Our Ref: AW/305/17/T
Your Ref:

Town & Country Planning Act 1990 (as amended)
Town & Country Planning (Tree Preservation) (England) Regulations 2012
Application for Works to Tree(s) on trees subject to a Tree Preservation Order (TPO)

Development Remove deadwood & 4m of lowest branch to 1 No. Monterey Pine tree
Location 8 Apple Grove Aldwick

REMOVE THIS
4m BRANCH

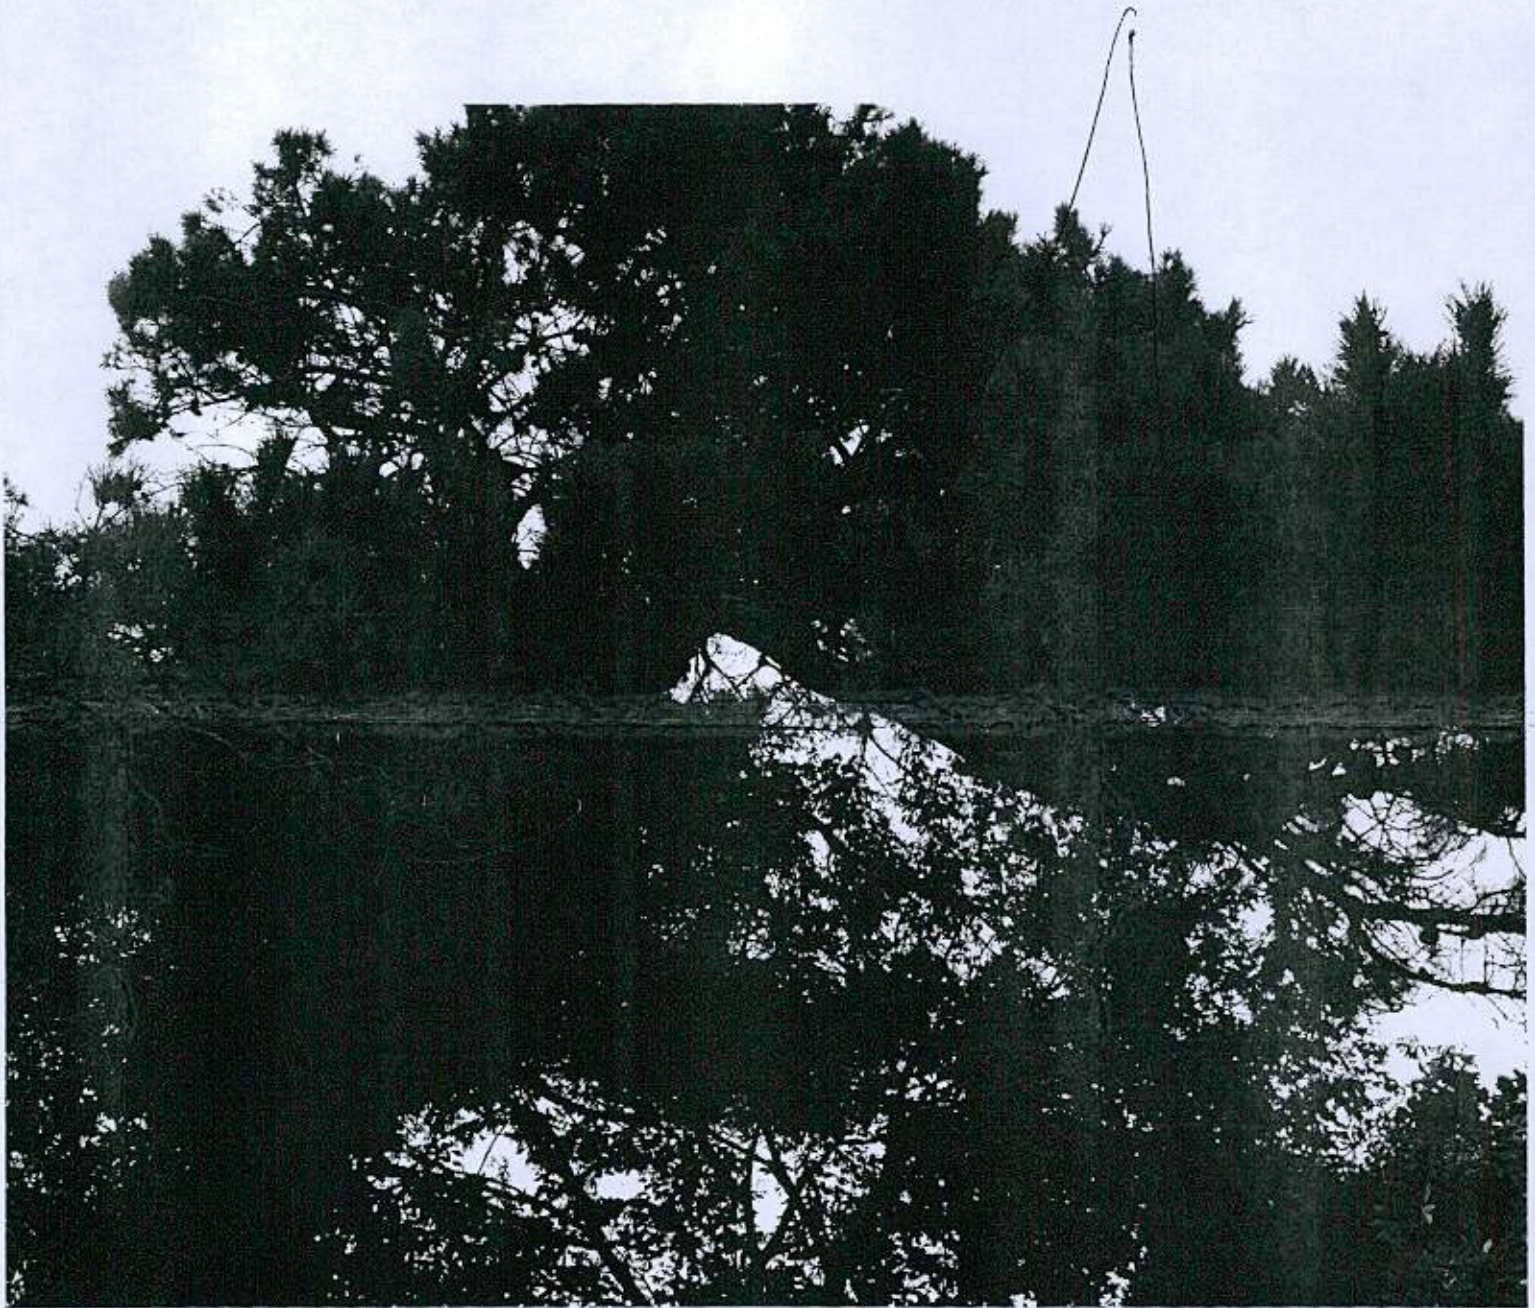
Please indicate which side of the tree the branch is located (north, south, east or west).
